**DEVIATION REQUEST
AND DECISION FORM**

Project Name : Falcon Meadows @ Bent Grass Filing No. 4
 Schedule No.(s) : 5301201061, 5301201062, 5301201063, 5301301054
 Legal Description : Falcon Meadows @ Bent Grass Filing No. 4

A deviation from the standards of or in Section **2.3.4 – 2.3.4** of the Engineering Criteria Manual (ECM) is requested.

LEMON GRASS ROAD (STREET L) - PUBLIC 50' R.O.W.
 25 MPH DESIGN SPEED (LOCAL)

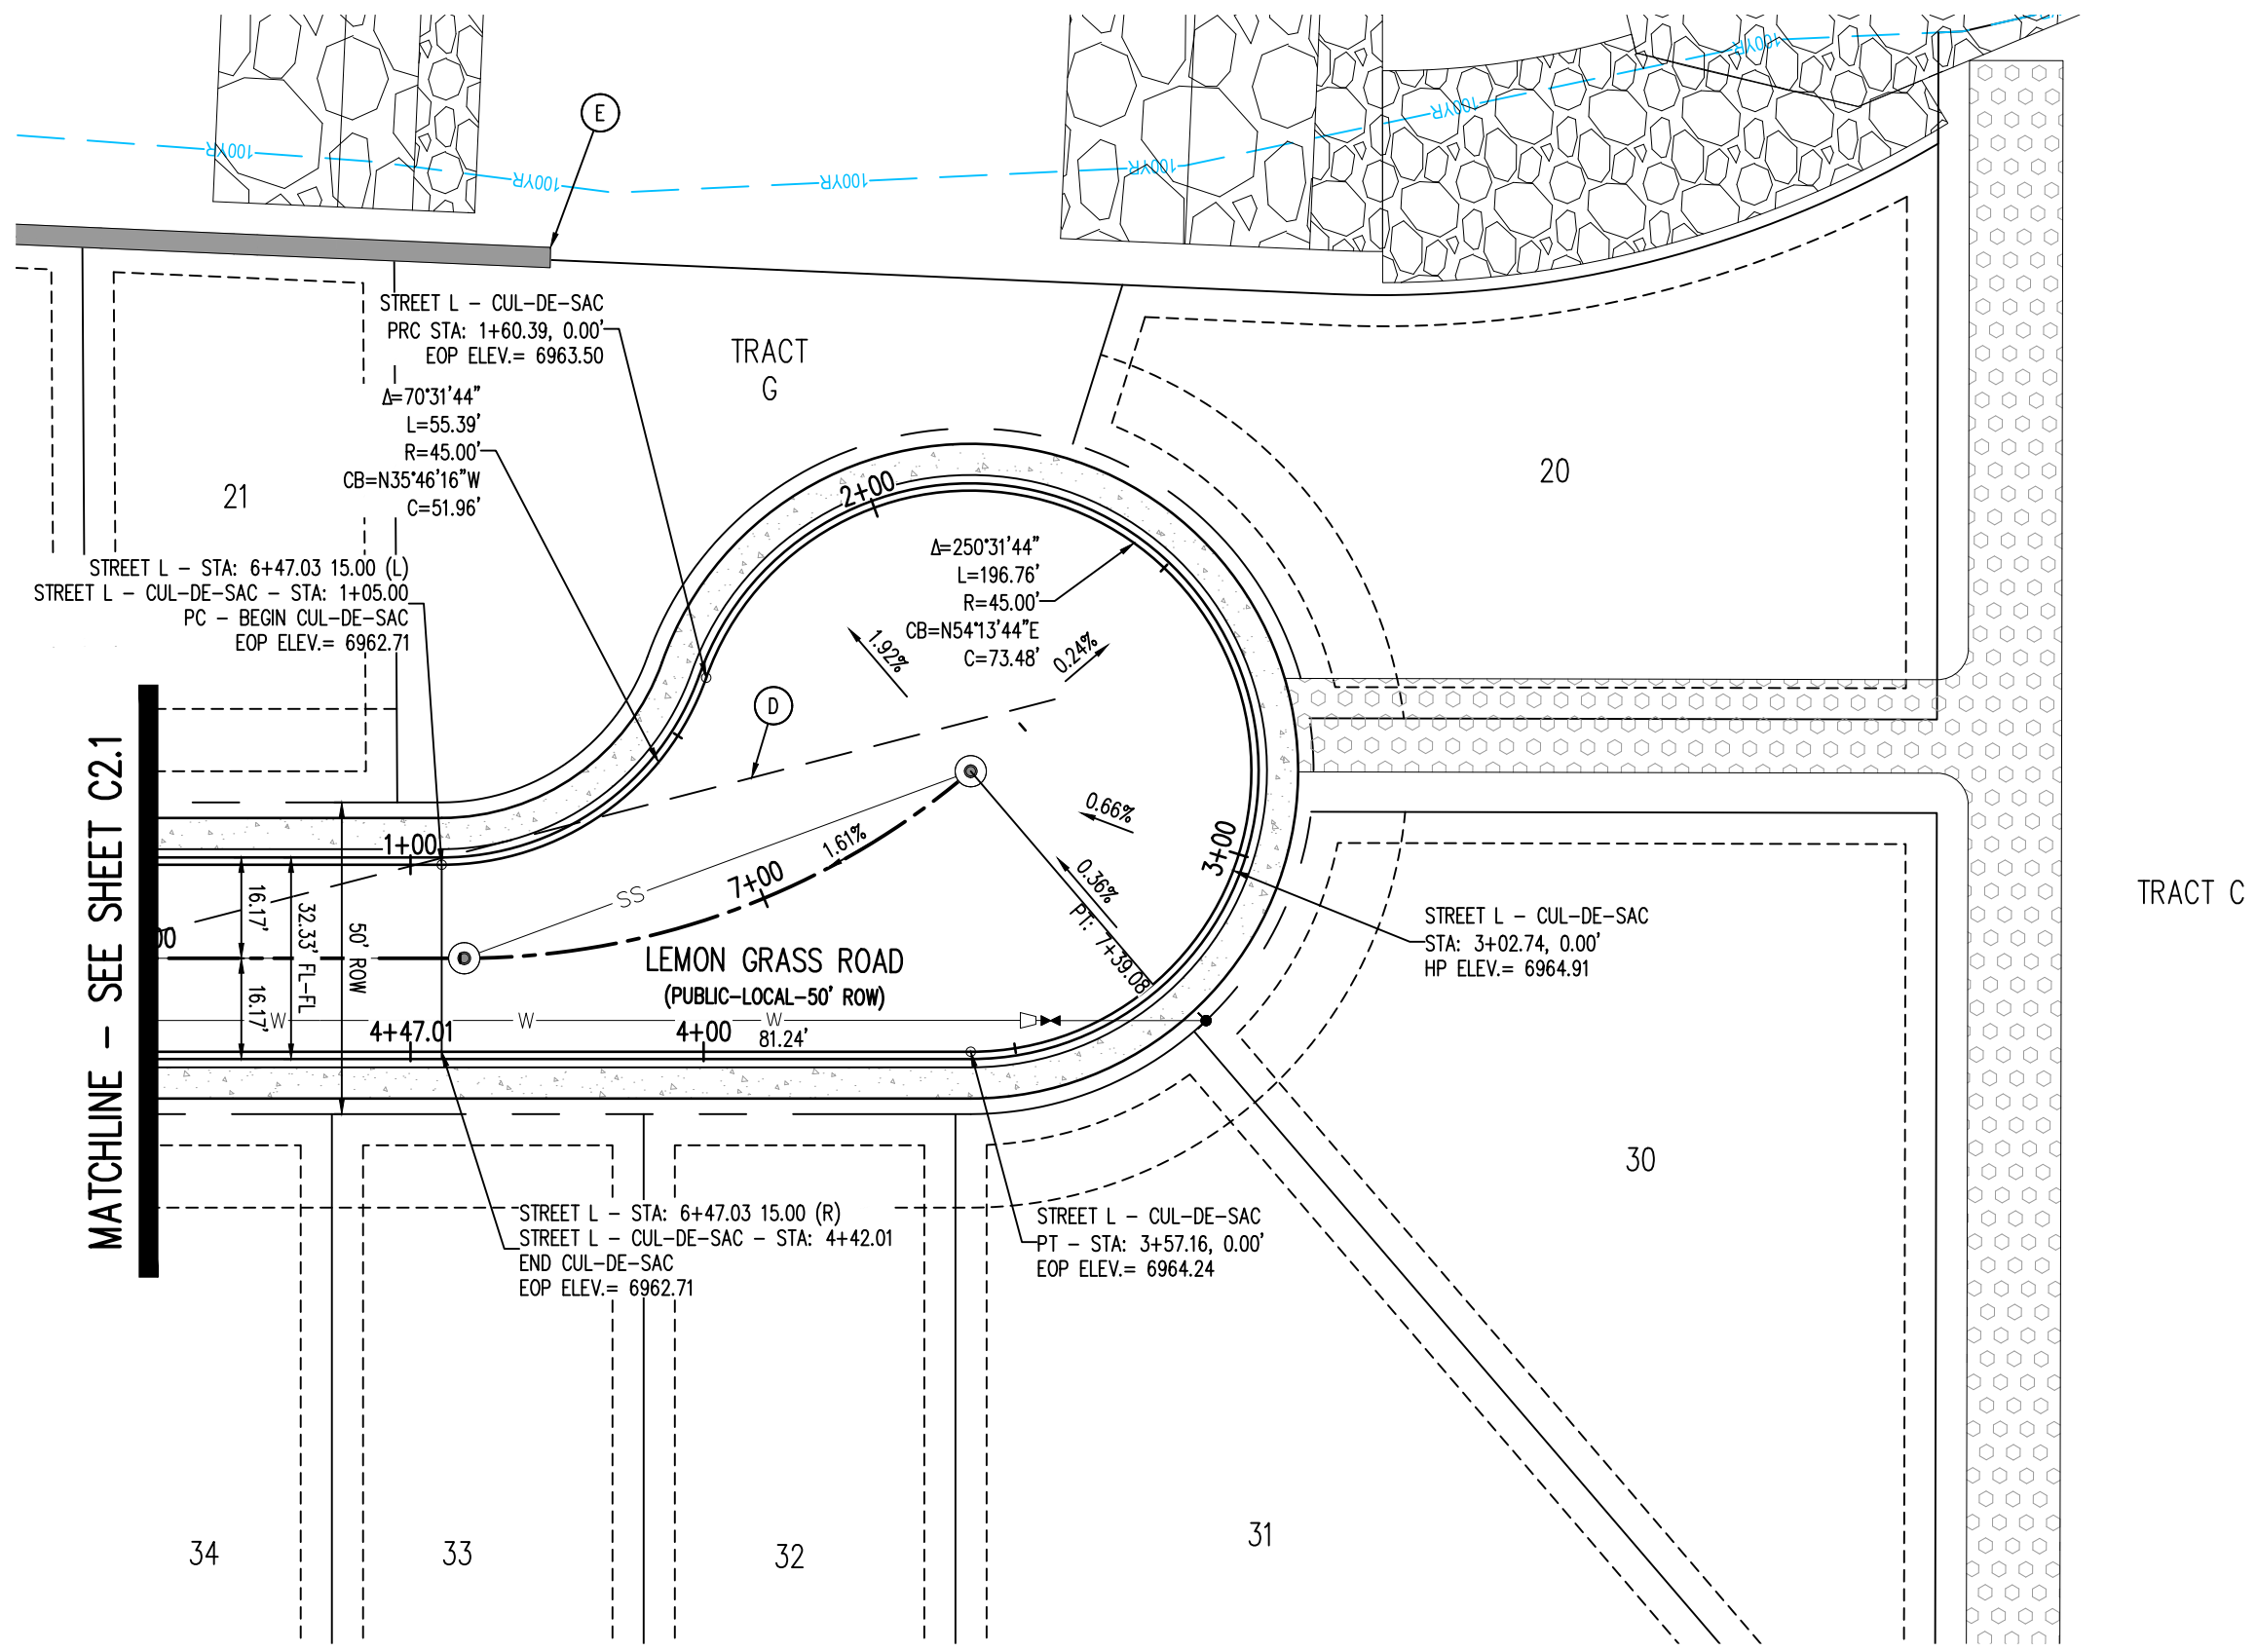
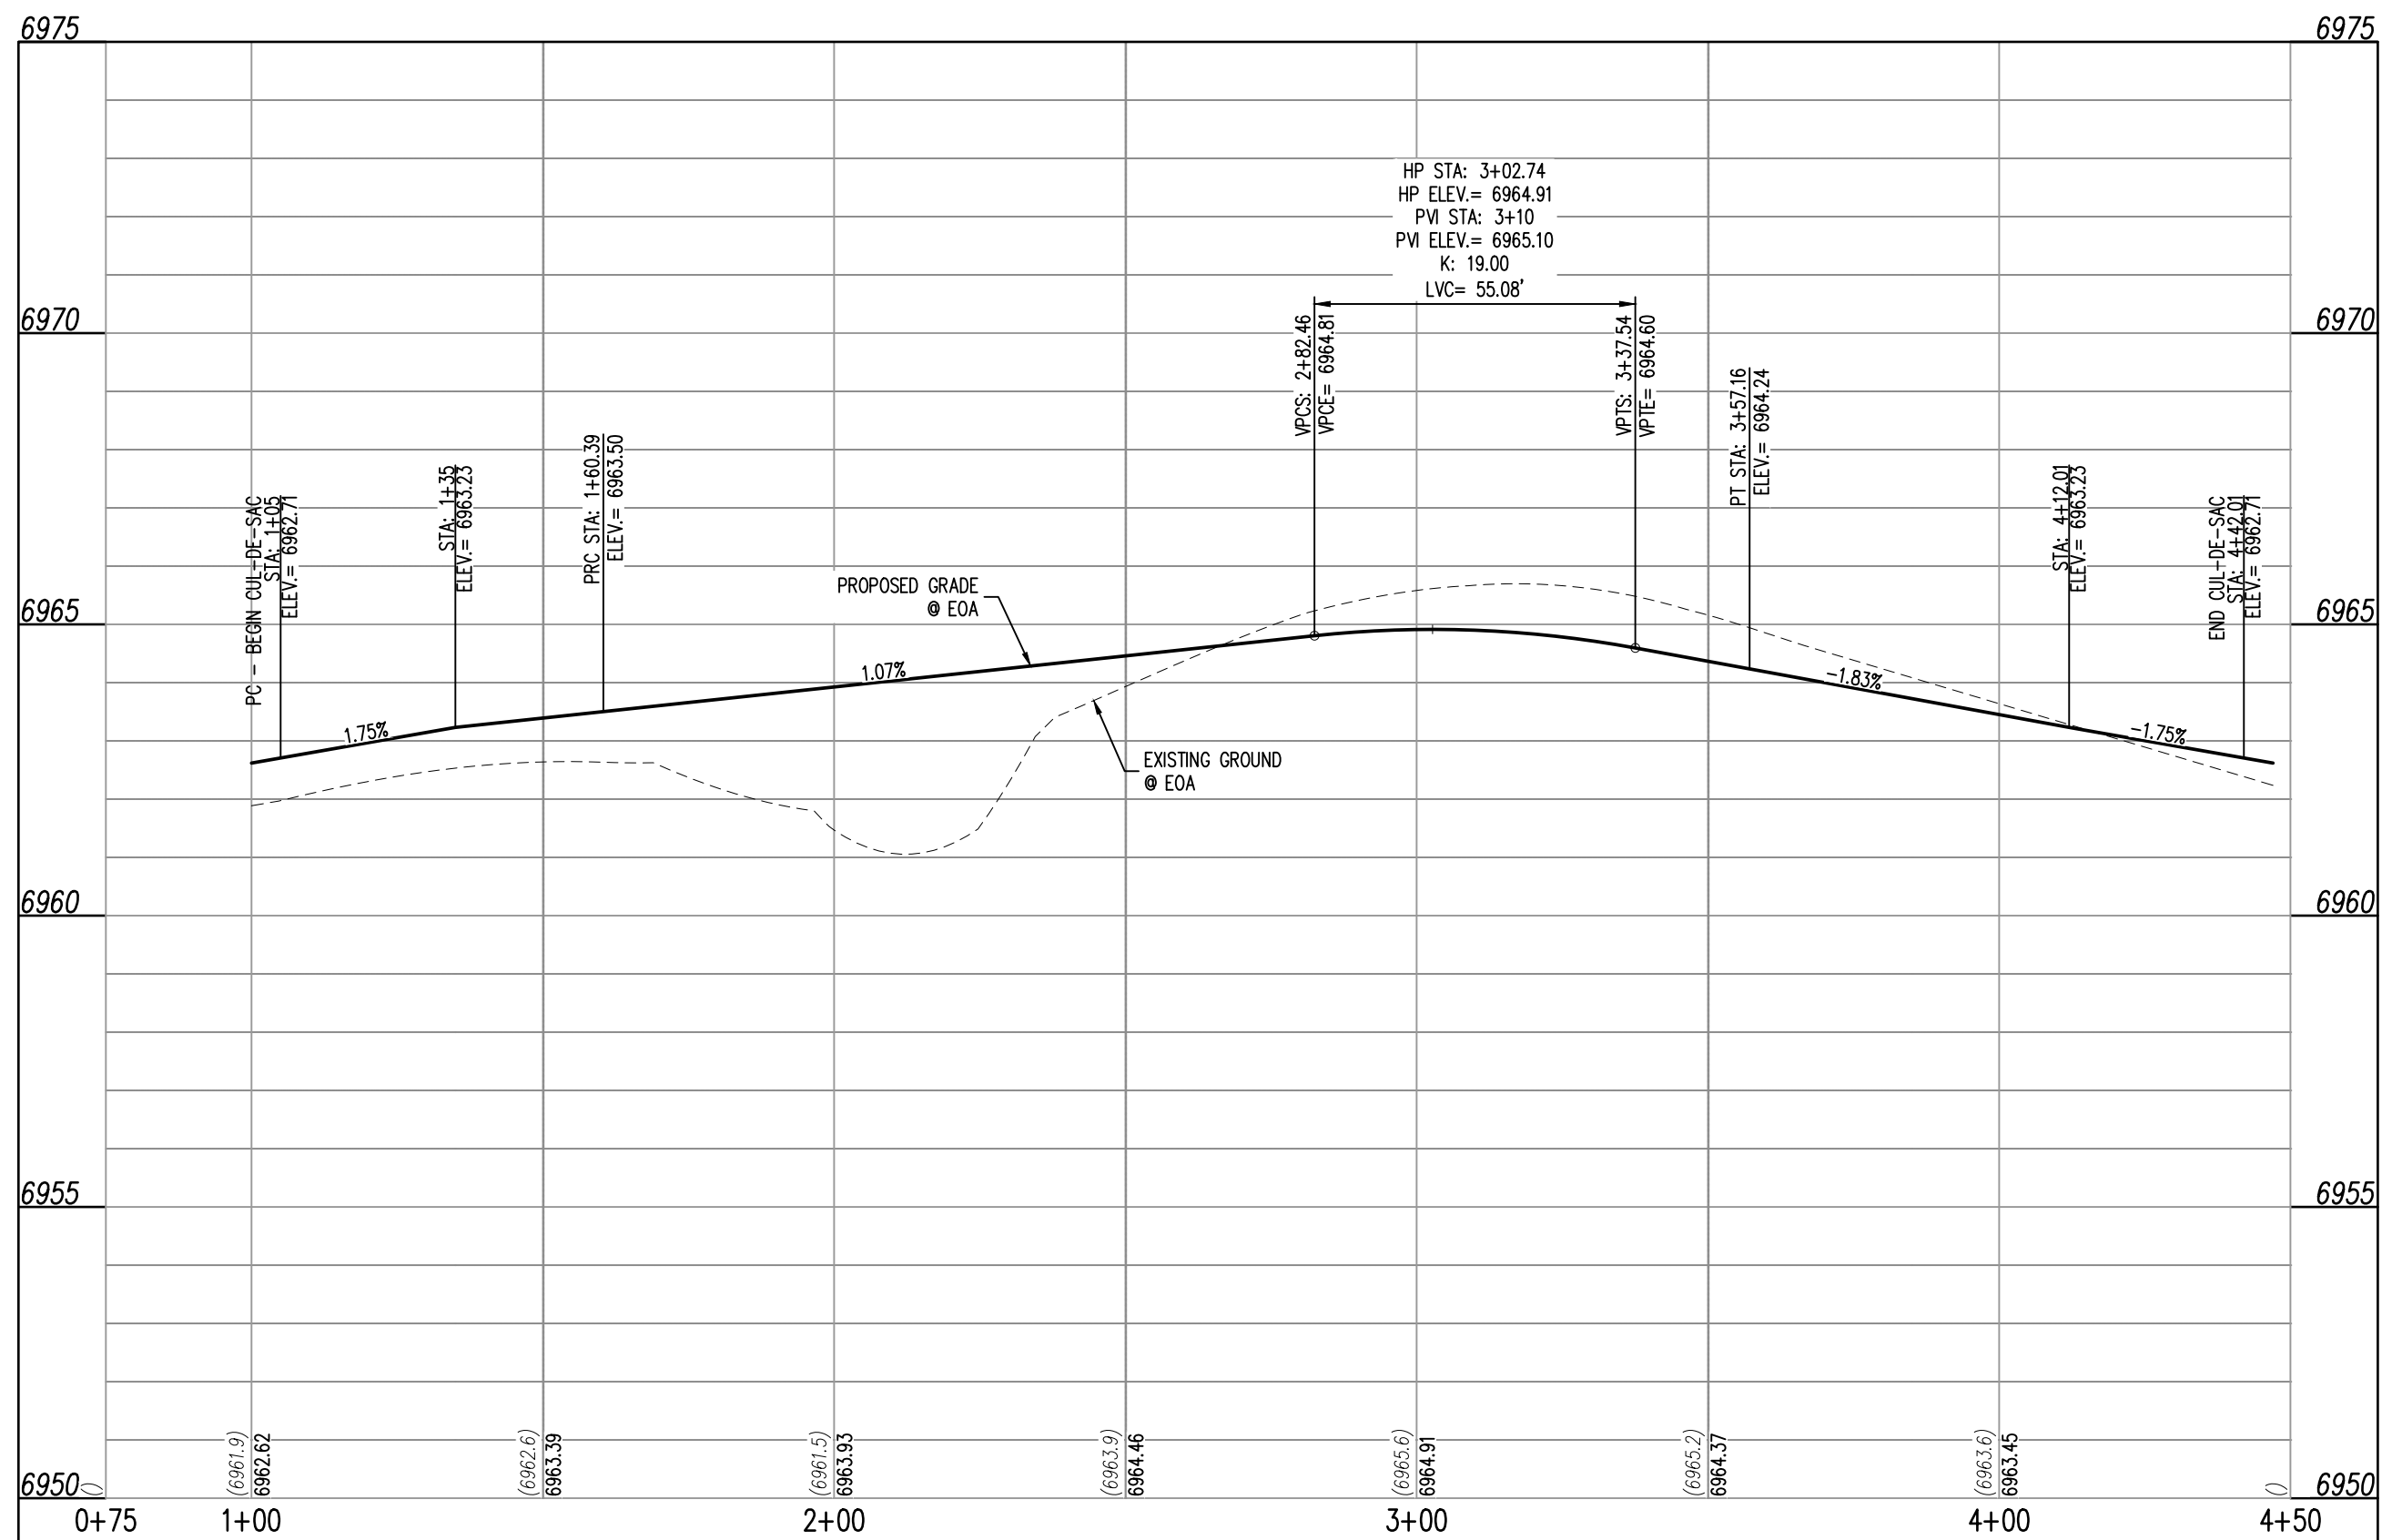
We are requesting a deviation because our minimum K values are not being met on our Lemon Grass Road Improvement Plans in our Construction Drawings and we are not able to adjust the design in this area sufficiently to meet the K value requirements.

We are proposing to maintain our current K values in our current plan. The K value for our non-compliant sag curve is 11.30 whereas the ECM standard is requiring a K value of 26. The K value for our non-compliant crest curve is 6.67 whereas the ECM standard is requiring a K value of 12.

Explain why Willmore, Silky Thread, and the north end of Lemon Grass Road cannot be revised to fix this situation.

What design speed would work with the vertical curves proposed?
Address AASHTO requirements.

Due to the existing roads that Lemon Grass Rd. is tying into (Bent Grass Meadows Drive and Willmore Drive), the K values presented are the maximum K values we can produce given the horizontal and vertical constraints, while maintaining compliance to ADA standards.
